Project Name:	Dearne Valley Parkway, Barnsley				
Client:	Gregory Property Group (GPG)				
Subject:	Response to Barnsley Highways Consultation Comments				
BGH Reference:	20-262-004.02				
Date:	05/09/2022				
Prepared by:	R. Donaldson	Checked by:	A. Bradley	Overview by:	M. Crabtree

Responses to BMBC August 2022 Consultation Comments

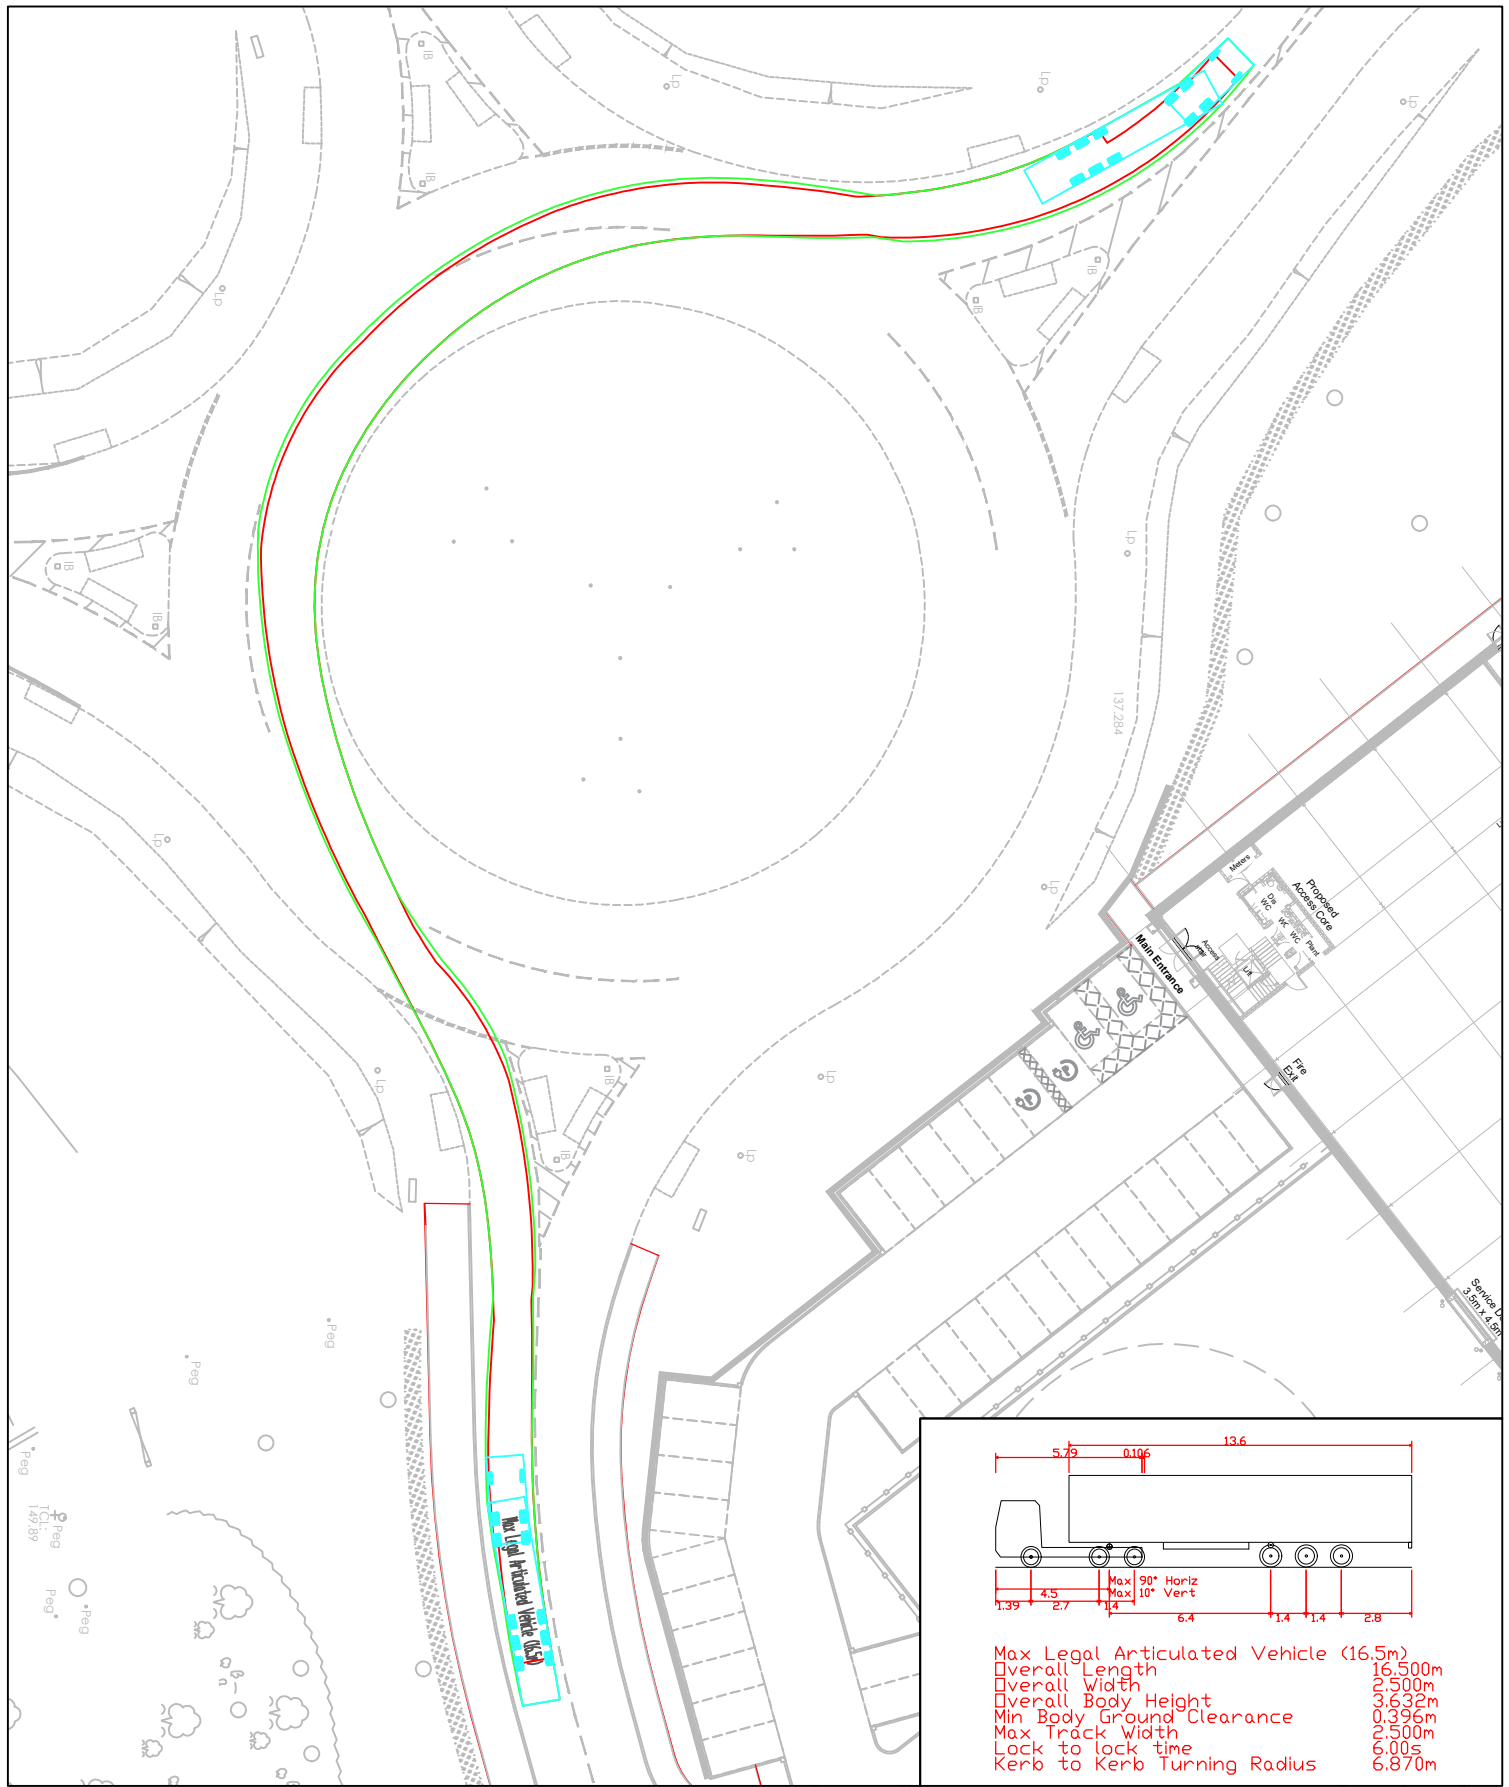
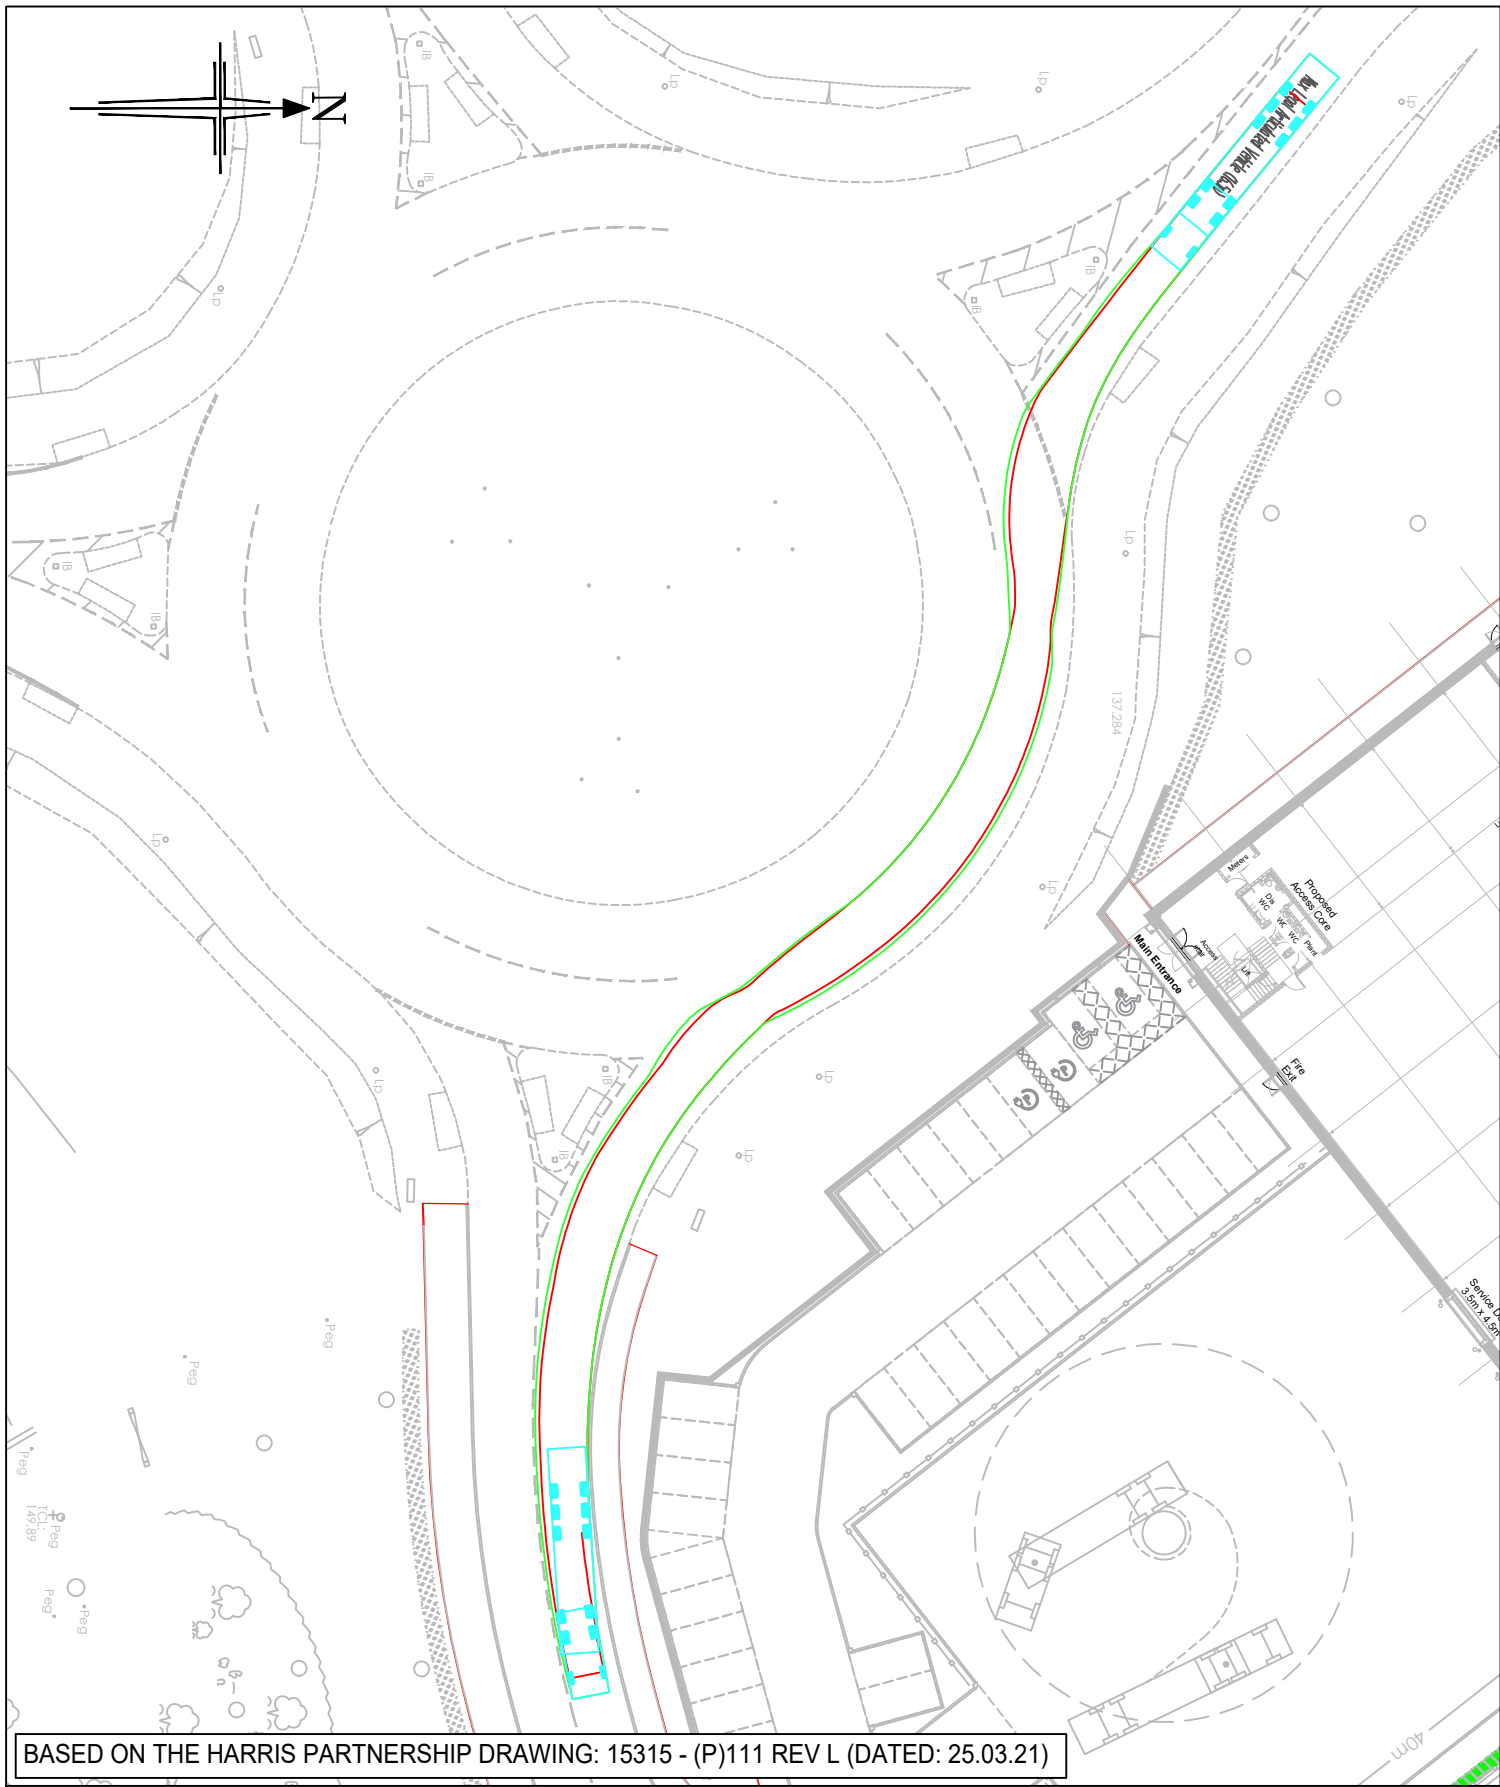
“The application proposes to provide a 7m wide access road bounded by a 2m wide footway on the northern side and a 3m wide footway on the southern side which will not be acceptable as stated in previous highway comments that required the applicant to provide a 3m shared use link should along both sides of the access road to tie in with existing highway provisions which has not been provided and the amended proposal will therefore not be acceptable.”

“The applicant should also note that junctions pose the greatest risk of collisions to all road users and therefore priority cycle crossings across the junctions between Units 1-2 and the northern side of the access road and the junction between the main access road and the access road to Unit 3 will be required to comply with LTN 1/20 Figure 10.13: Priority Crossings of Cycle Tracks At Side Roads which should be shown on a revised drawing along with the 3m wide foot/cycleway on the northern side of the access road which should include a 3m wide foot/cycleway on the eastern side of the access road to the cycle parking and main entrance to Unit 3 with priority cycle crossings provided across the junctions of the access road with the car park access roads.”

“Junction/access spacing is slightly substandard providing 18m centre line to centre line between Unit 1 and Unit 3 and 38m between Units 1 and 2”

10. The proposed site access road will be 7.3 metres wide, which is appropriate for an industrial development which is accessed by HGVs (also see the swept path analysis of two HGVs passing in response to the previous comment). The proposed site layout has been amended to provide a 3 metre wide shared footway/cycleway along both the northern and southern sides of the proposed site access road.

12. Proposed pedestrian/cycle priority crossovers are now indicatively shown on the proposed site layout plans at each of the accesses into Units 1, 2 and 3. This arrangement is indicative only at this stage, based on guidance contained in LTN 1/20 for a priority crossing with no set back. The exact layout of the proposed pedestrian/cycle priority crossovers are to be agreed at the detailed design stage, noting that these will form part of the private site access road layout.

34. Given the nature of the proposed site access road, which is short in length to the east of the roundabout junction with Sheffield Road, vehicle speeds will naturally be restricted to below 20mph. Therefore given this, and that visibility between the accesses to the proposed units is good, it is considered that the individual accesses to the three units are adequately spaced to enable safe access to and from the units.
